**SSD 9978934 – COCKLE BAY PARK  
RESPONSE TO SUBMISSIONS – TIANLONG, W HOTEL SUBMISSION**

**Table 1      Response to Tianlong/Greaton submission (letter dated 8 September 2023)**

Figure 3: Cockle Bay Park Reconfiguration

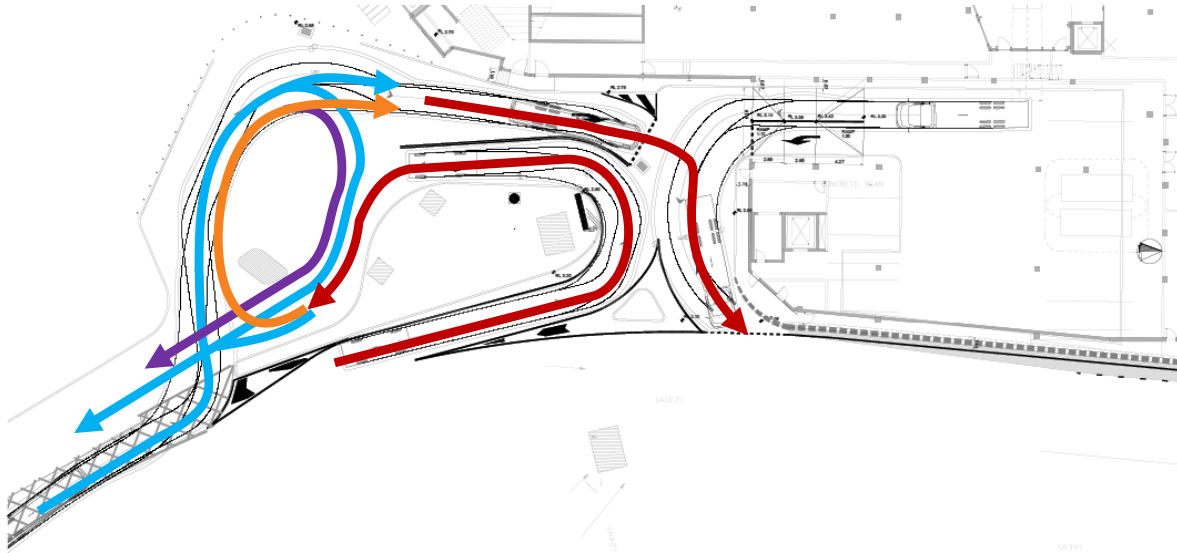
5.2	Tianlong requests that the columns be removed and that the associated kerblines proposed in SSD 9978934 be relocated to allow bus and coach set-down and pick-up to occur in a designated zone away from the hotel set-down and pick-up area without blocking egress from The Ribbon. Tianlong also requests that the design of the loading dock interface with The Ribbon be revised. As proposed, it continues to put forward an unsafe traffic outcome.	A revised layout has been developed in consultation with Tianlong and Stantec that addresses the columns, kerblines and hotel set down. The revised design together with a Technical Note prepared by Aurecon is included in <b>Appendix A</b> .

No.	Issues Raised	EU Response
	<p>The CBP Redevelopment proposes to remove the southern section of Wheat Road (directly north of The Ribbon) and replace it with a reconfigured two-way Harbour Street/ Wheat Road intersection (left in/left-out) that provides access to a proposed CBP loading dock with capacity for 14 vehicles, with the dock expected to generate 400 trips daily.</p>	
STC01	<p>The original CBP interface proposal (Henning Larsen drawing no. CBP-HEN-DRW-A-DA-1010 dated 03 September 2021) that formed the state significant development application proposed for all traffic associated with The Ribbon to enter and exit the site via the new left-in/ left-out intersection, with The Ribbon access road forming a minor leg to a new T-intersection created in between the two sites thus requiring The Ribbon egress traffic to give priority to vehicles entering and exiting the proposed Cockle Bay Park loading dock. Following discussions between the CBP project team, Greateon and Stantec in early 2022, the CBP interface proposal was amended in late 2022 so that only vehicles departing The Ribbon were required to use the new left-in/ left-out intersection on Harbour Street.</p>	Noted

2.1 & 2.2	<p><b>Operational issues and impact to the existing built environment</b></p> <p>Mr Seaward has identified the following operational problems posed by the design put forward by SSD 9978934, being:</p>	A revised layout has been developed in consultation with Tianlong and Stantec that addresses these concerns. The revised design together with a Technical Note prepared by Aurecon is included in <b>Appendix A</b> .
